SUBJECT: Engineering Review Comment
Mountain View Electric Association Inc. (MVEA)

Project Name: Waterbury Filing 1 – Final Plat

Project Number: SF237

A PORTION OF SW 1/4 SECTION 28, A PORTION OF THE SE 1/4 SECTION 29, A PORTION OF THE NW 1/4 SECTION 33, TOWNSHIP 12 SOUTH, RANGE 64 WEST OF THE SIXTH PRINCIPAL MERIDIAN, EL PASO COUNTY, COLORADO

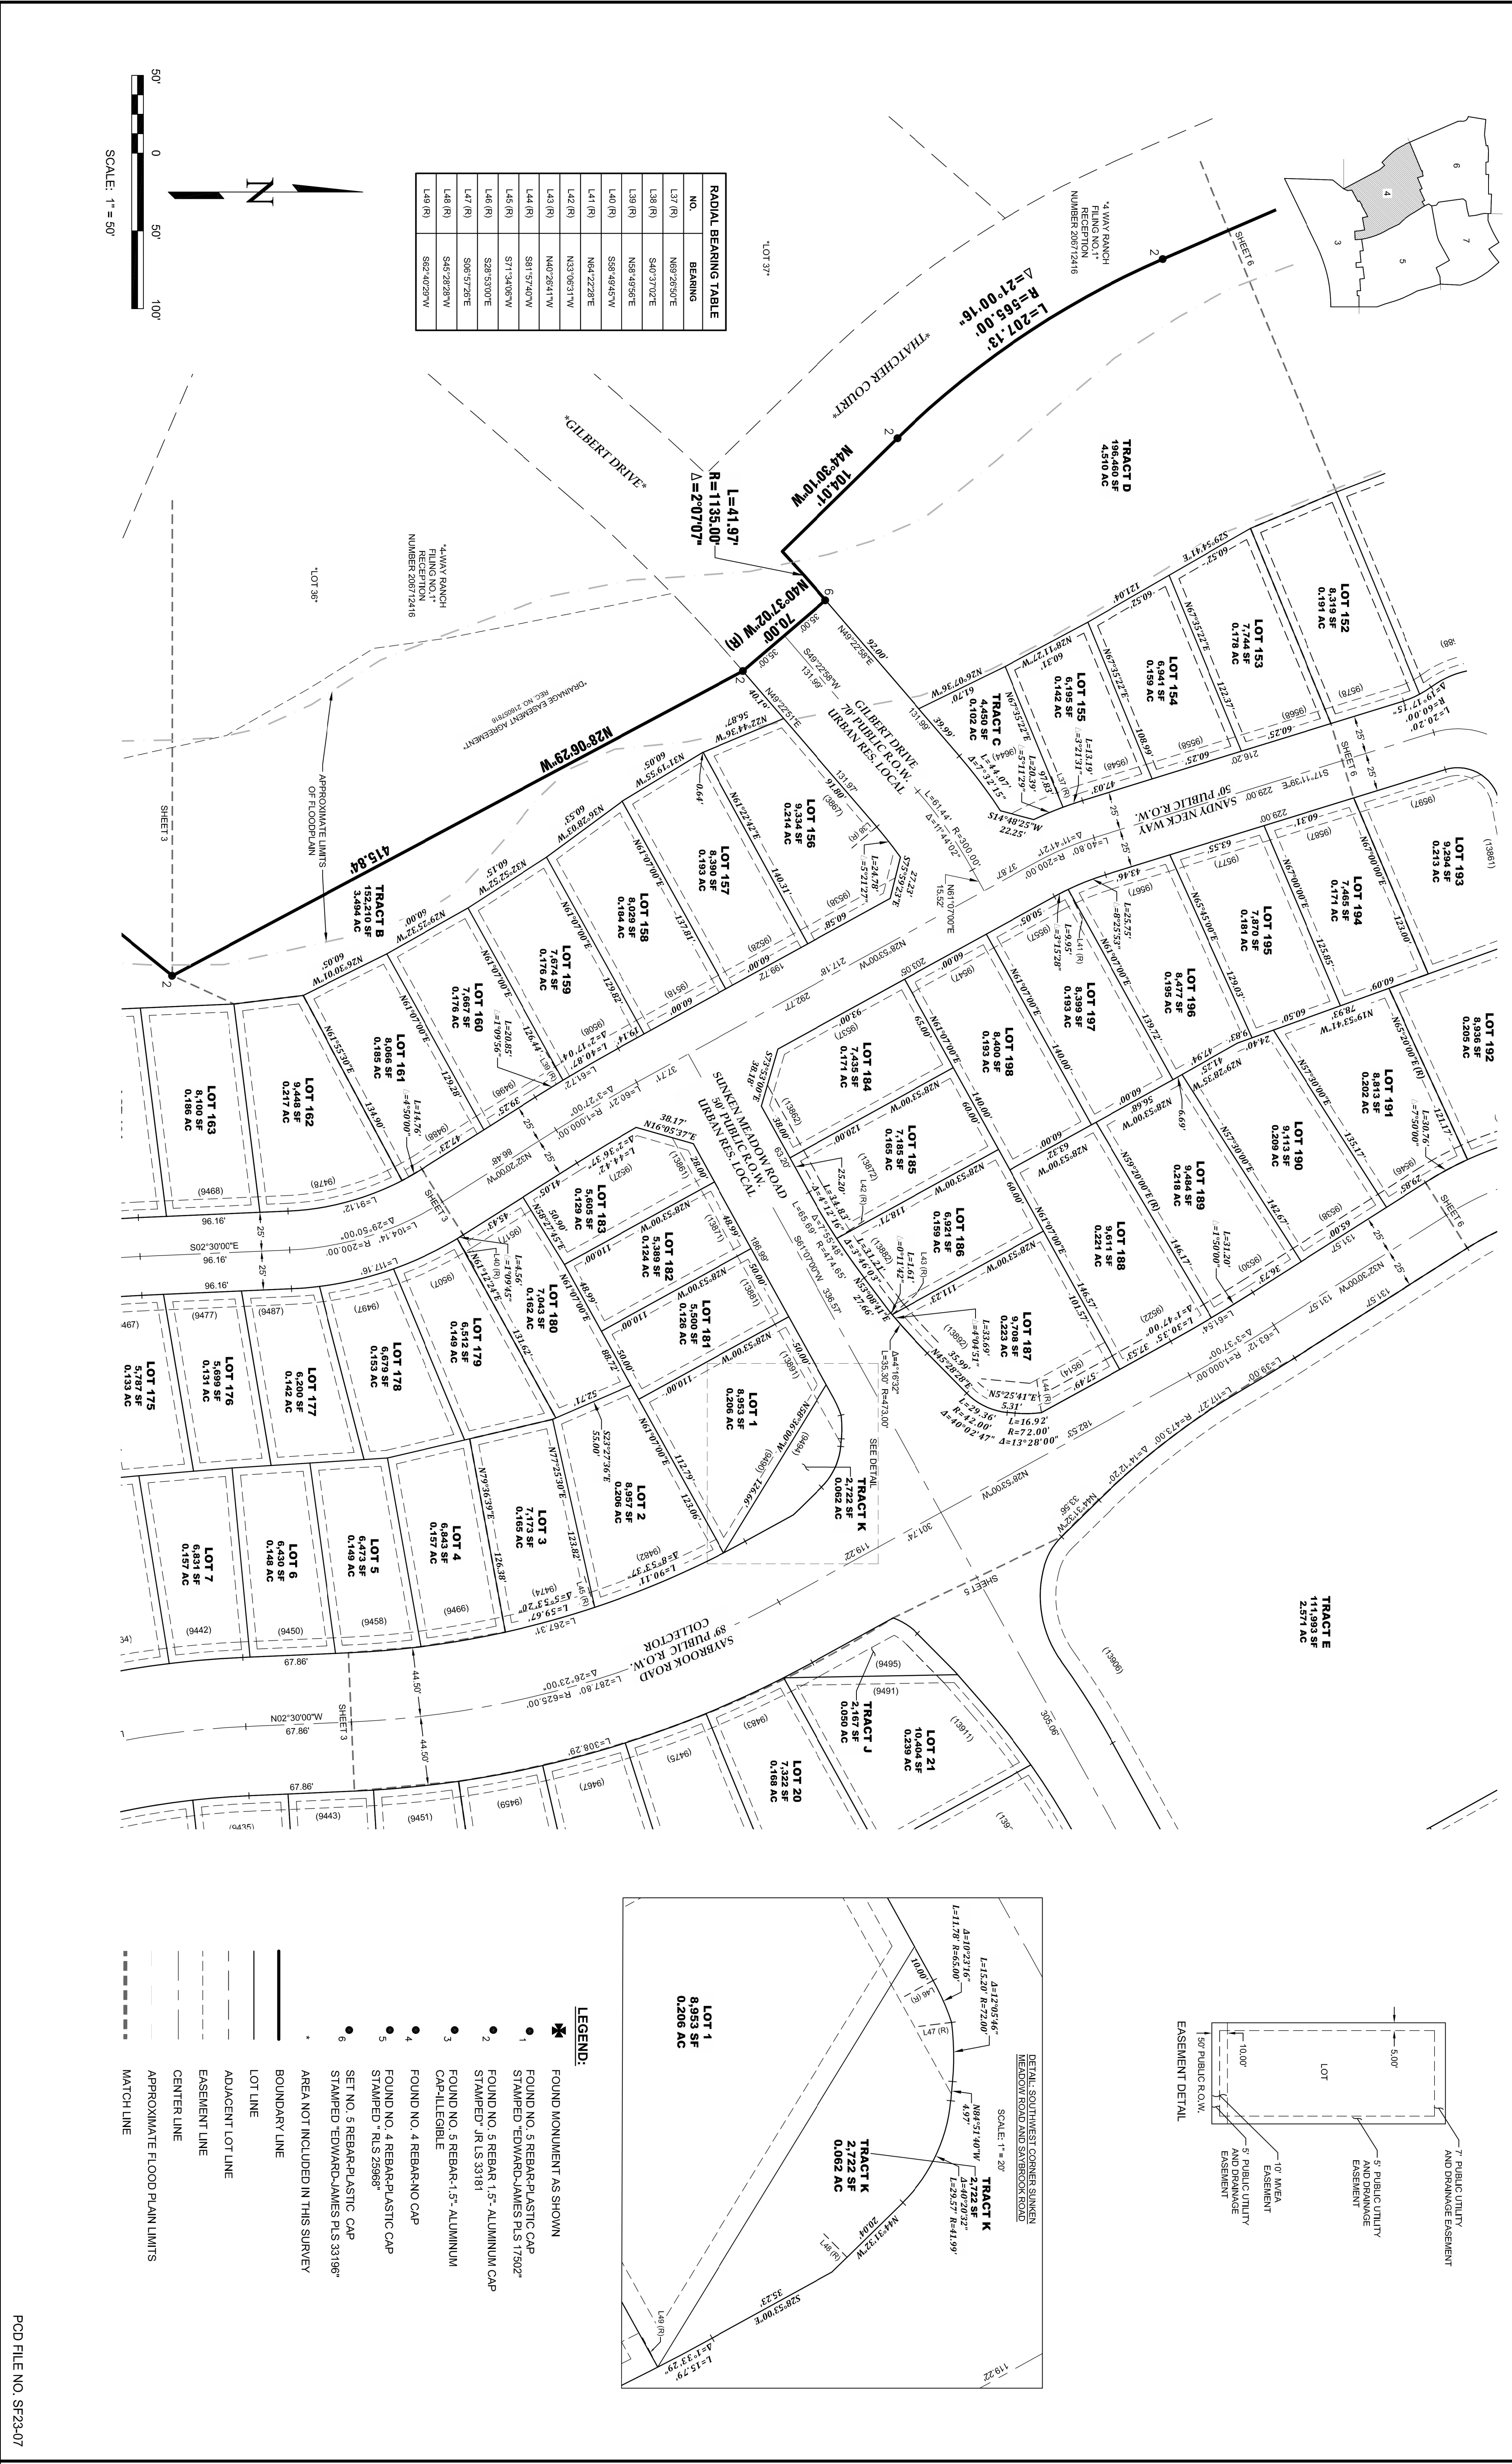
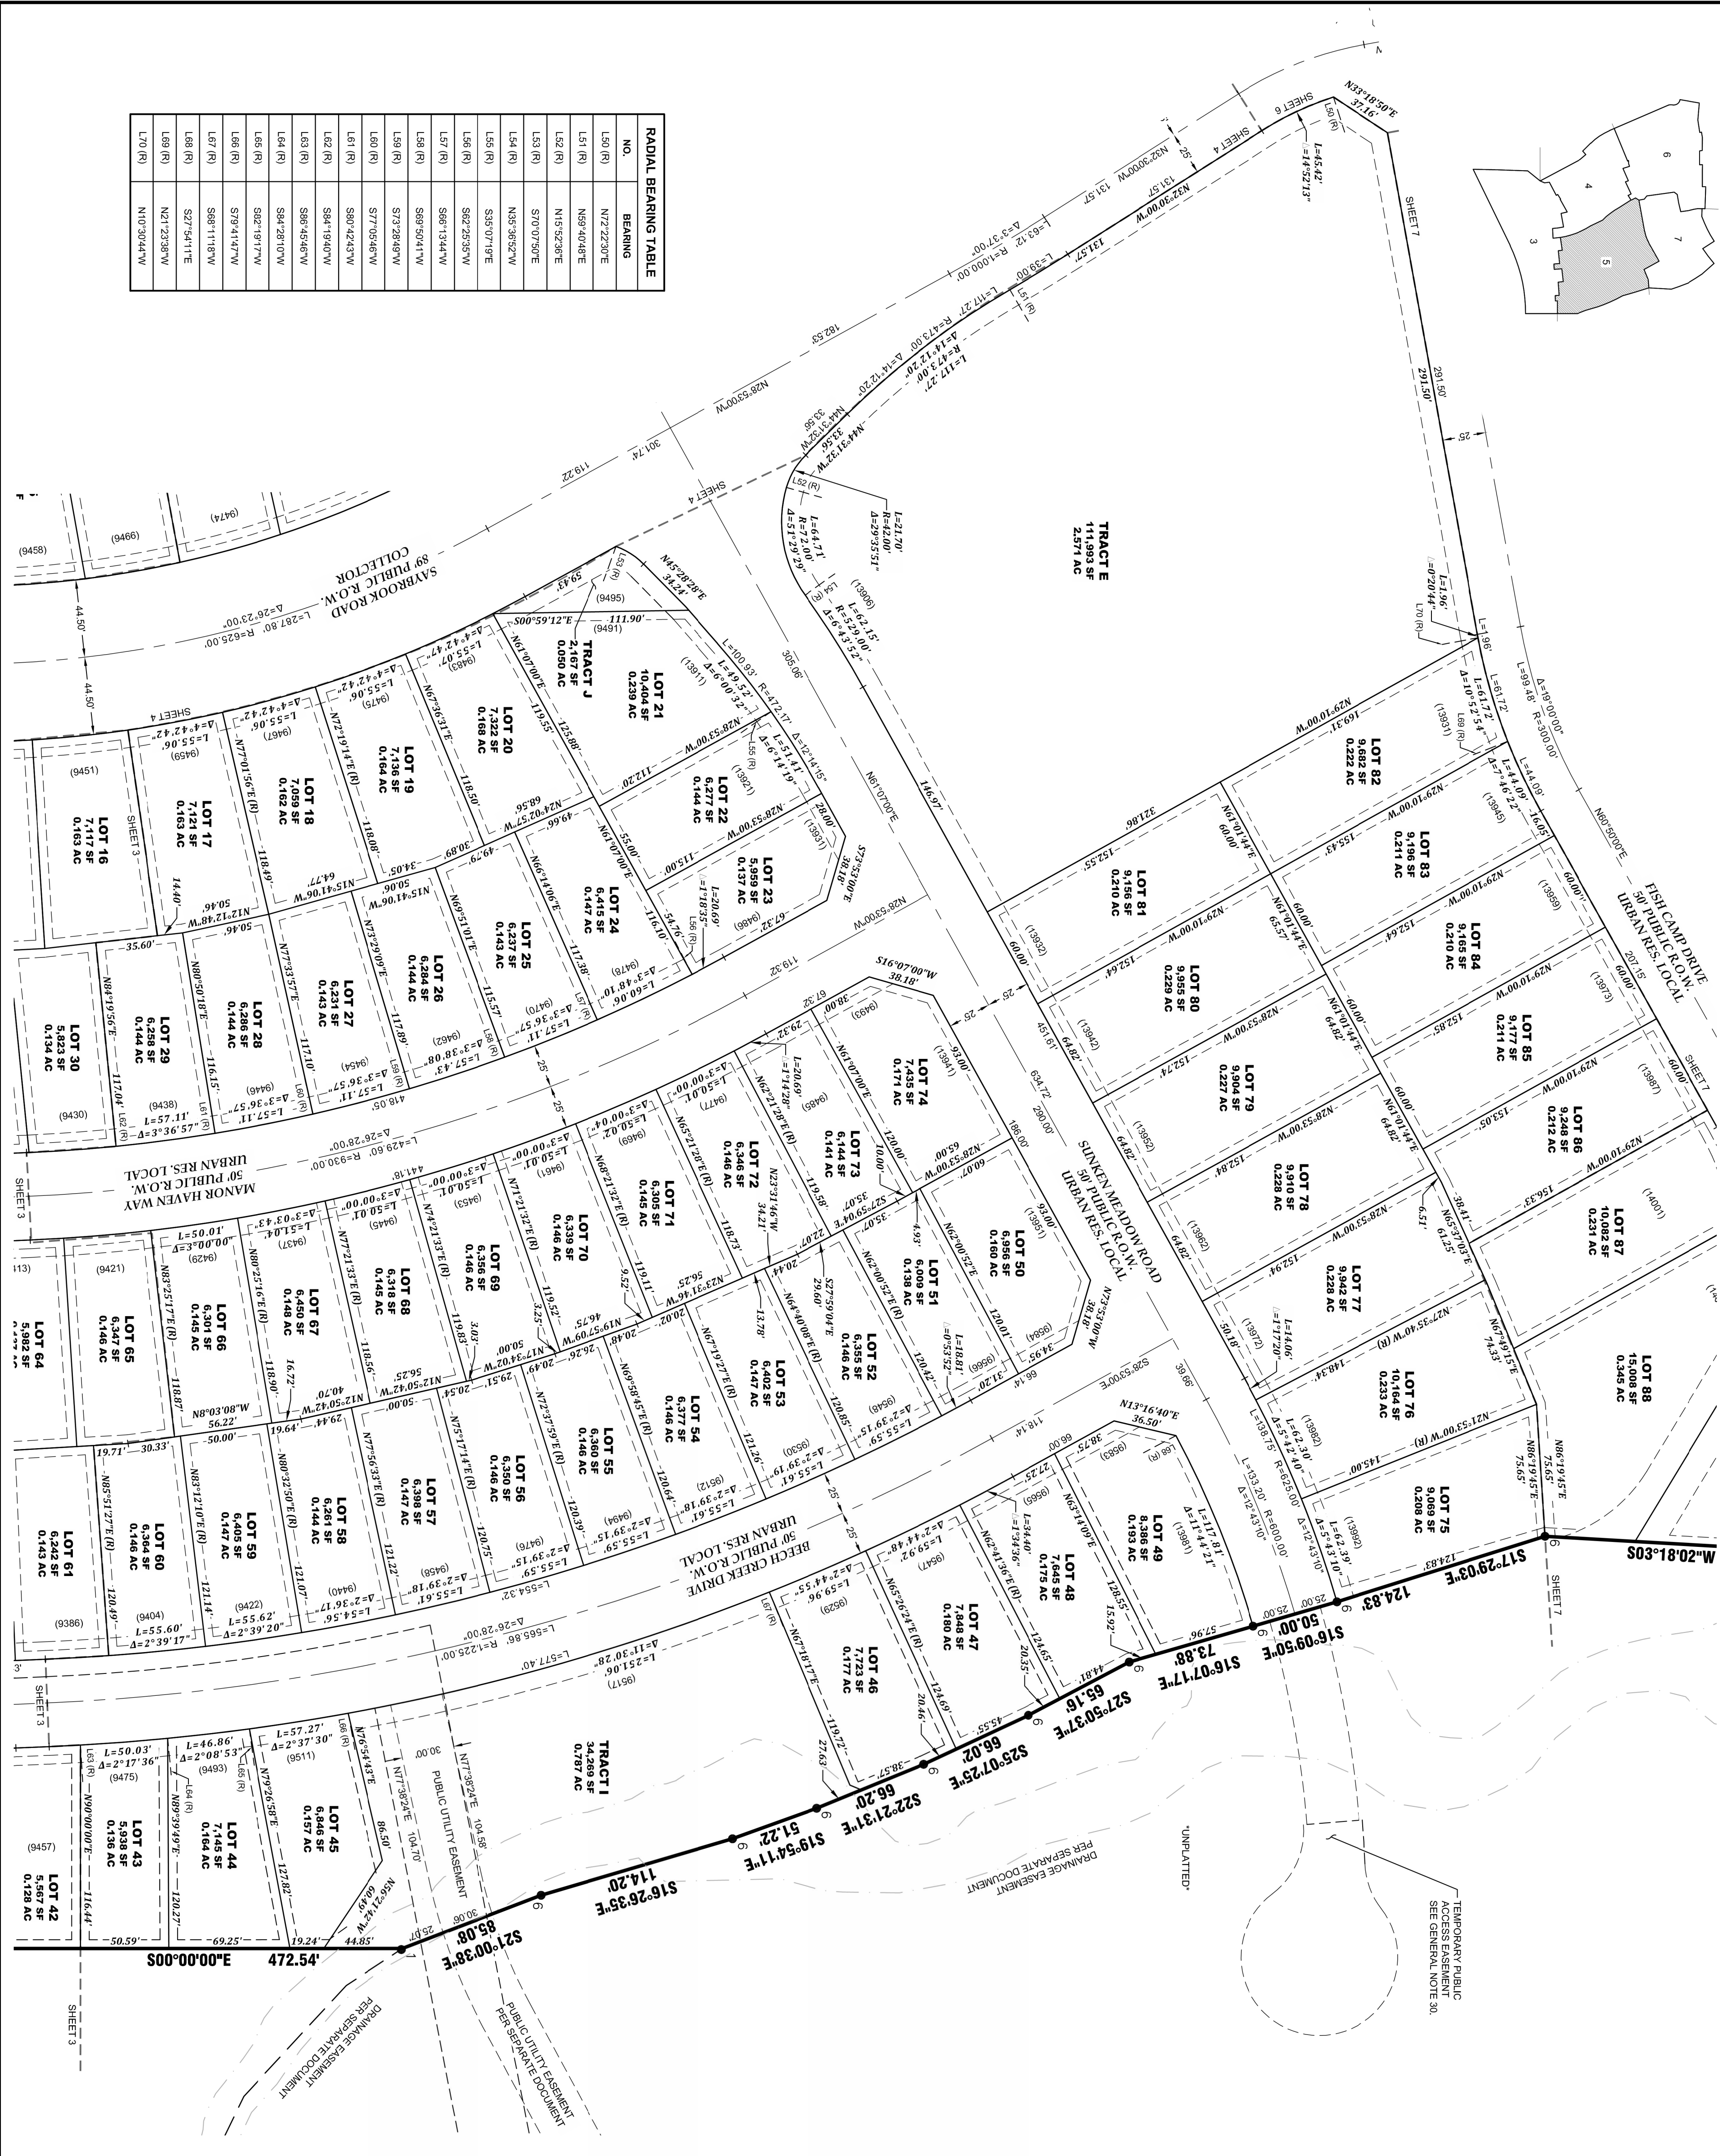
After review of the plat, MVEA is amendable to all the easements **except** MVEA requests a ten (10) foot front lot utility easement in addition to any public improvement easements and **all** tracts include easements. The Tract Table does not align with General Note #7 – Tract Ownership Maintenance. MVEA also requests the platting of MVEA's existing facilities with easements on the plat. Additional easements may be required.
